Re: 7501 Holly Ave., Guardian Storage

Temporary Certificate of Occupancy – Transportation Development

Re: Guardian Storage-Holly Conceptual Grading and Drainage Plan, Engineer's Stamp Date-no stamp- (C19/D056)

Grading and Drainage Plan

CONCEPTUAL GRADING AND DRAINAGE PLAN GUARDIAN SELF STORAGE

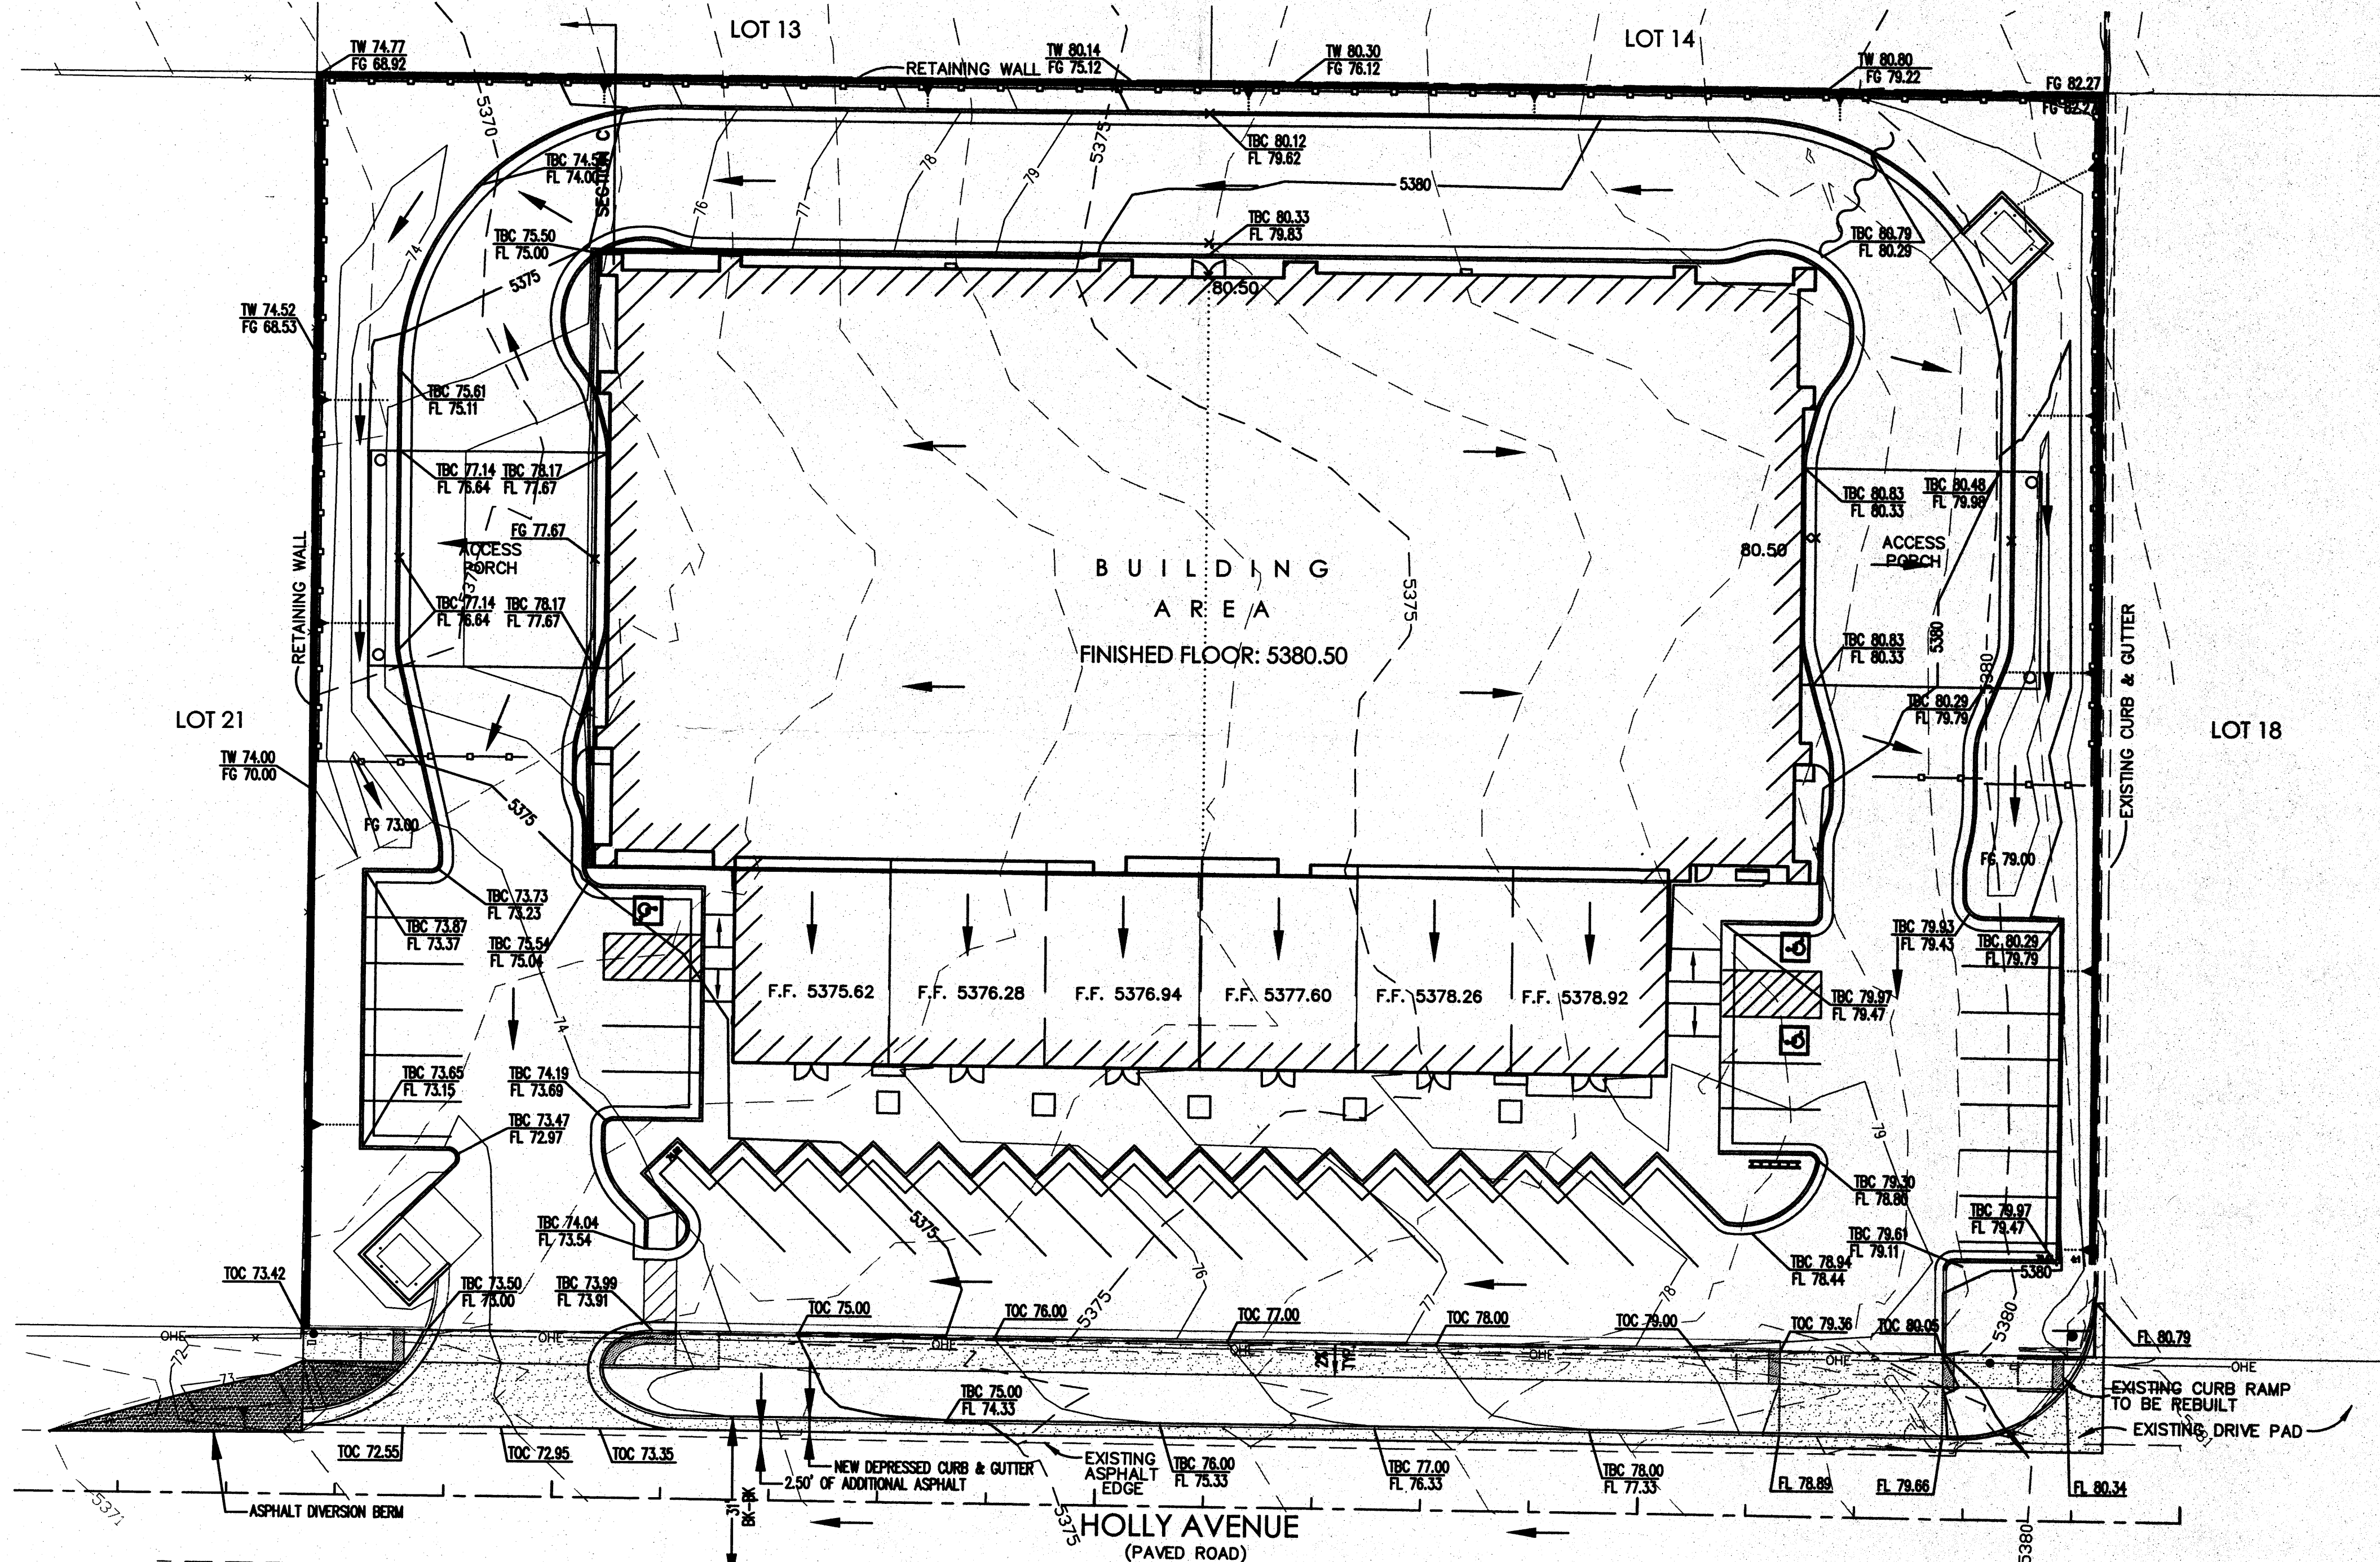
• Show existing contours on the lot to the west.

Provide flow line elevations on Holly Avenue.

Additional elevations should be given on sidewalks.

Standard flow and volume calculations per the DPM will be required.

Provide a vicinity map.

GRADING AND DRAINAGE PLAN GUARDIAN SELF STORAGE

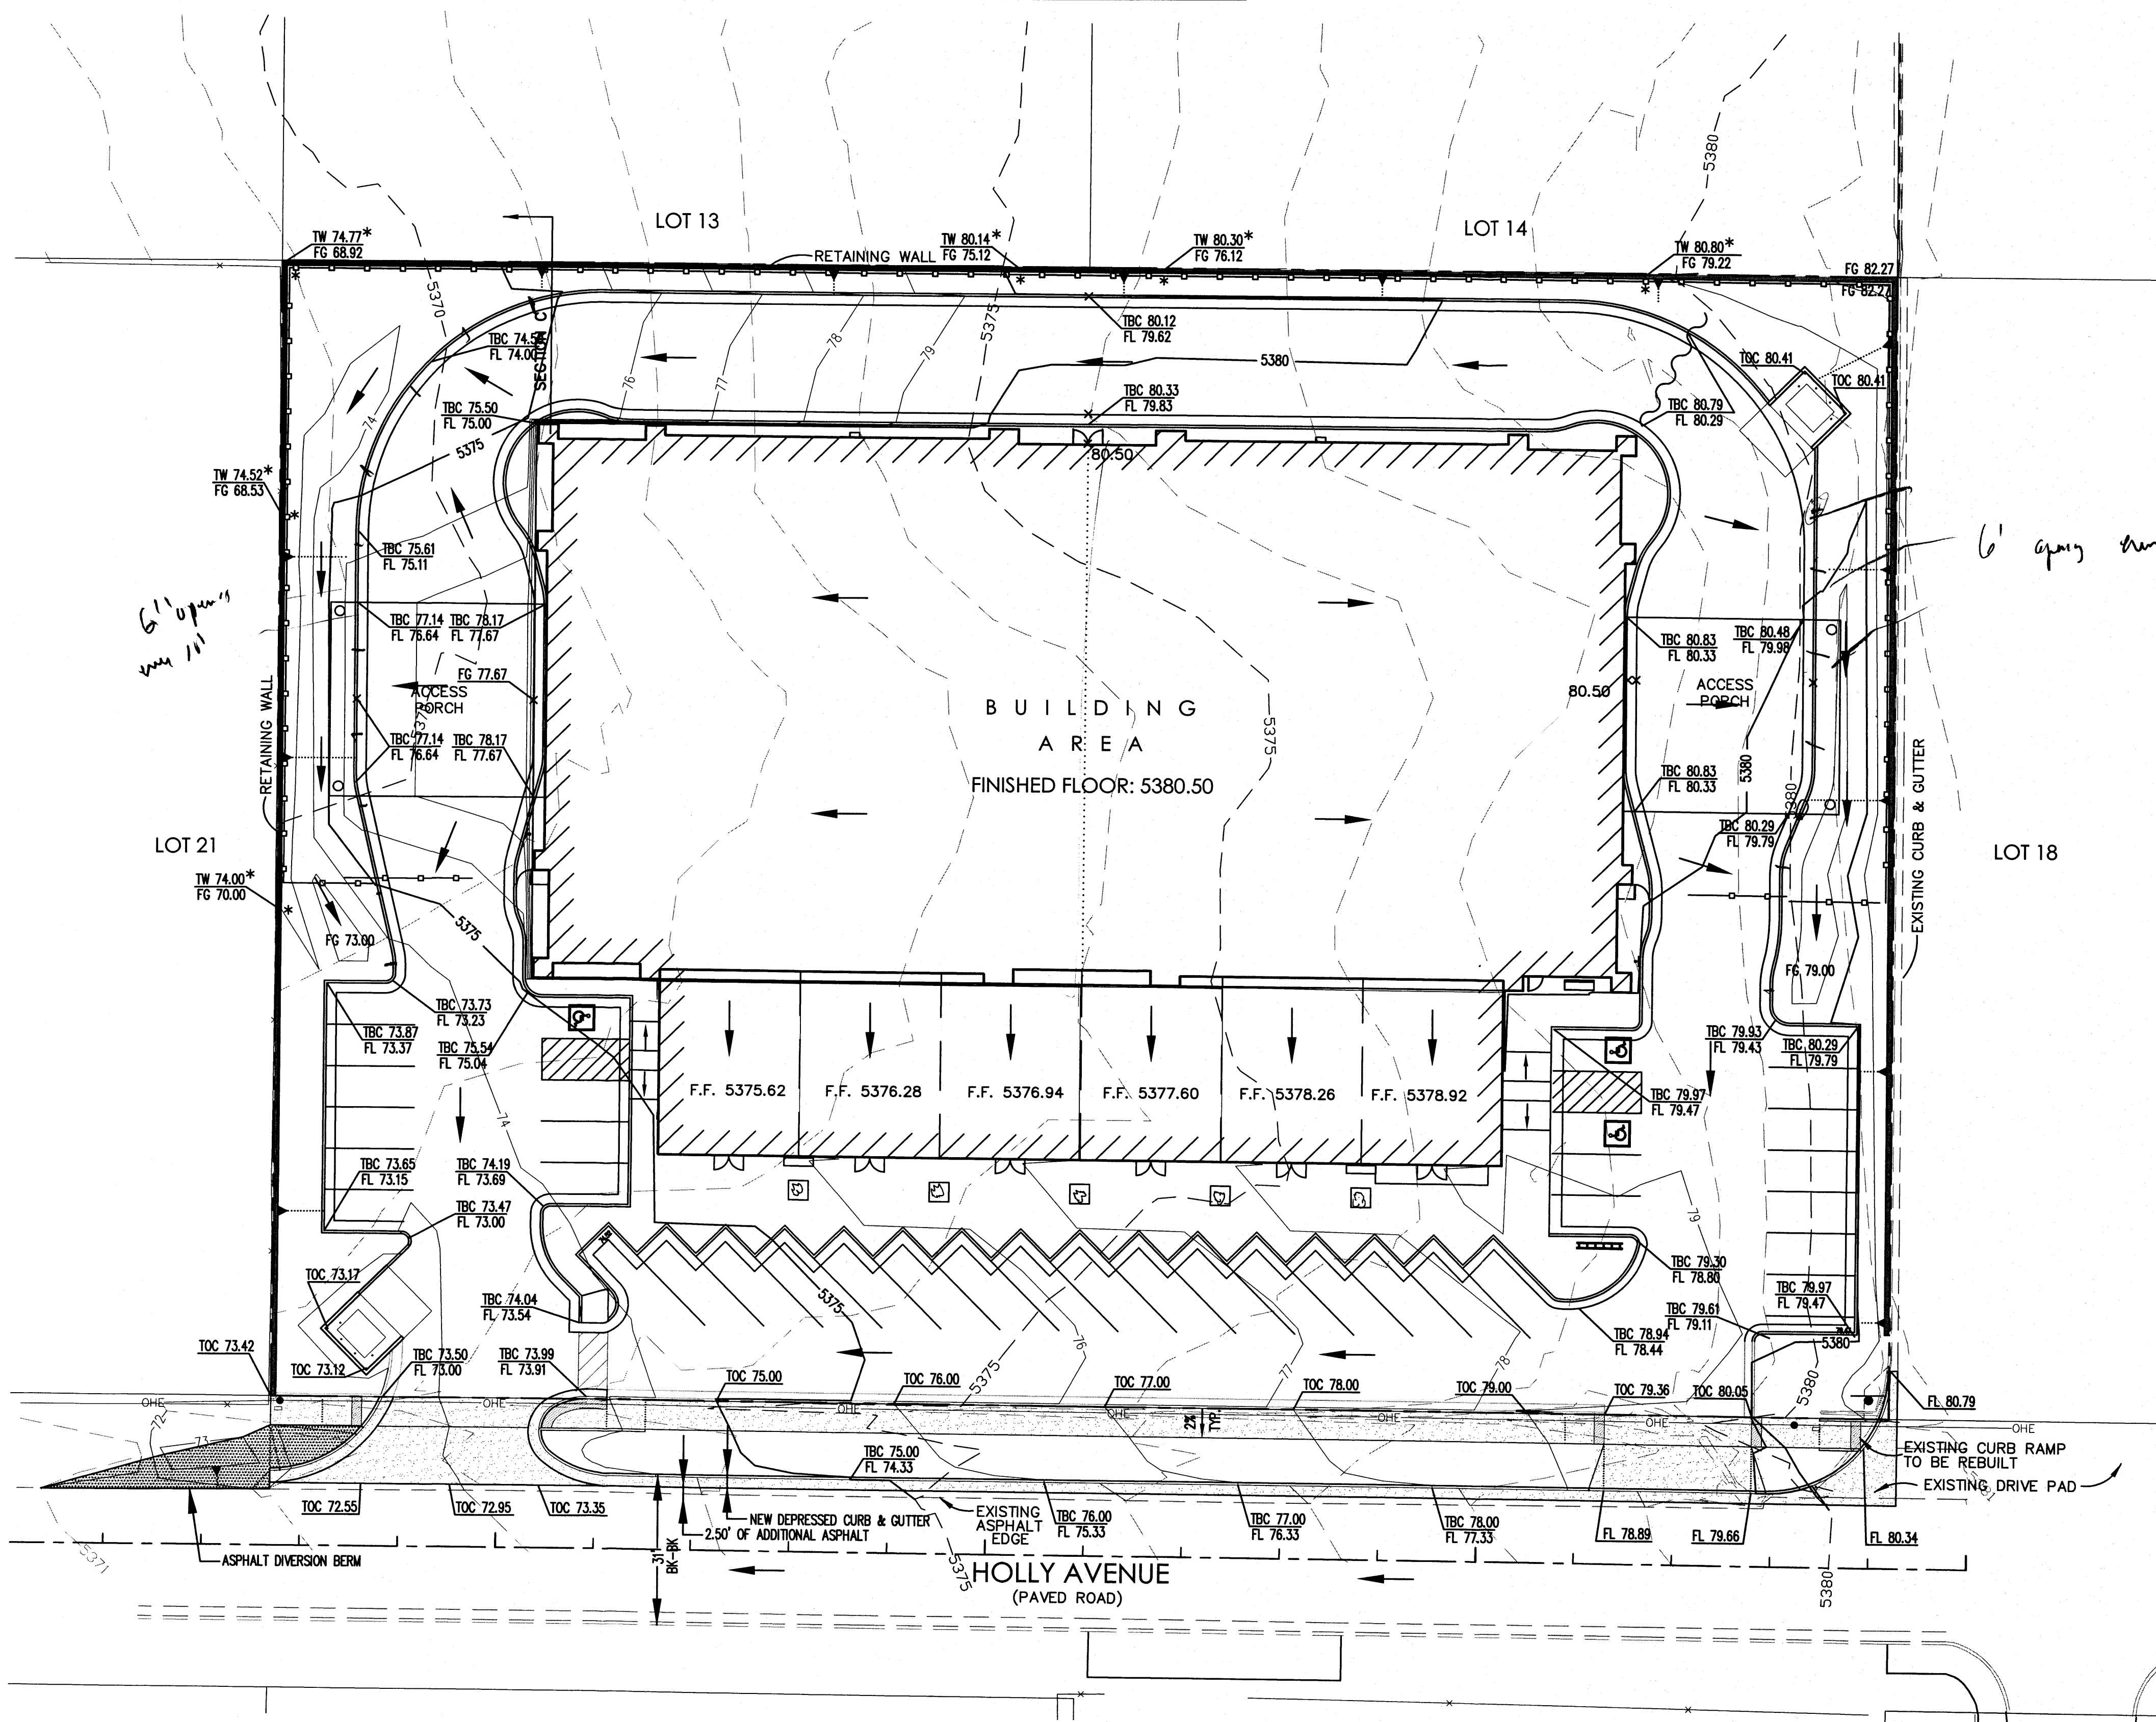
• The asphalt Diversion Berm on Holly Ave. is not functioning as required. The asphalt berm should be directing flows across Holly Ave and not allowing erosion on the edge of Holly Ave and entering the property to the west of Guarding Storage.

• How are the roof flows entering the landscape areas? How and where are the curb cuts being placed, what are the sizes? A build note should be provided.

- The plans must be stamped, signed and dated by a PE.
- Show existing contours surrounding the site.
- Additional elevations should be given on sidewalks.
- Standard flow and volume calculations per the DPM are required.
- Provide a table showing existing flows and developed flows.
- Show the elevations at the dumpster sites and the inlet tying into the SAS system.
- Show a section of the retaining walls. A max height of 8' can not be exceeded unless a variance is obtained. Also if retaining more than 18" a designed drawing must be provided.

Hydrology is requesting that proposed landscape areas be depressed to retain/infiltrate the rain that falls on them. This project requires a National Pollutant Discharge Elimination System (NPDES) permit for storm water discharge. Prior to Certificate of Occupancy release, Engineer Certification per the DPM checklist will be required.
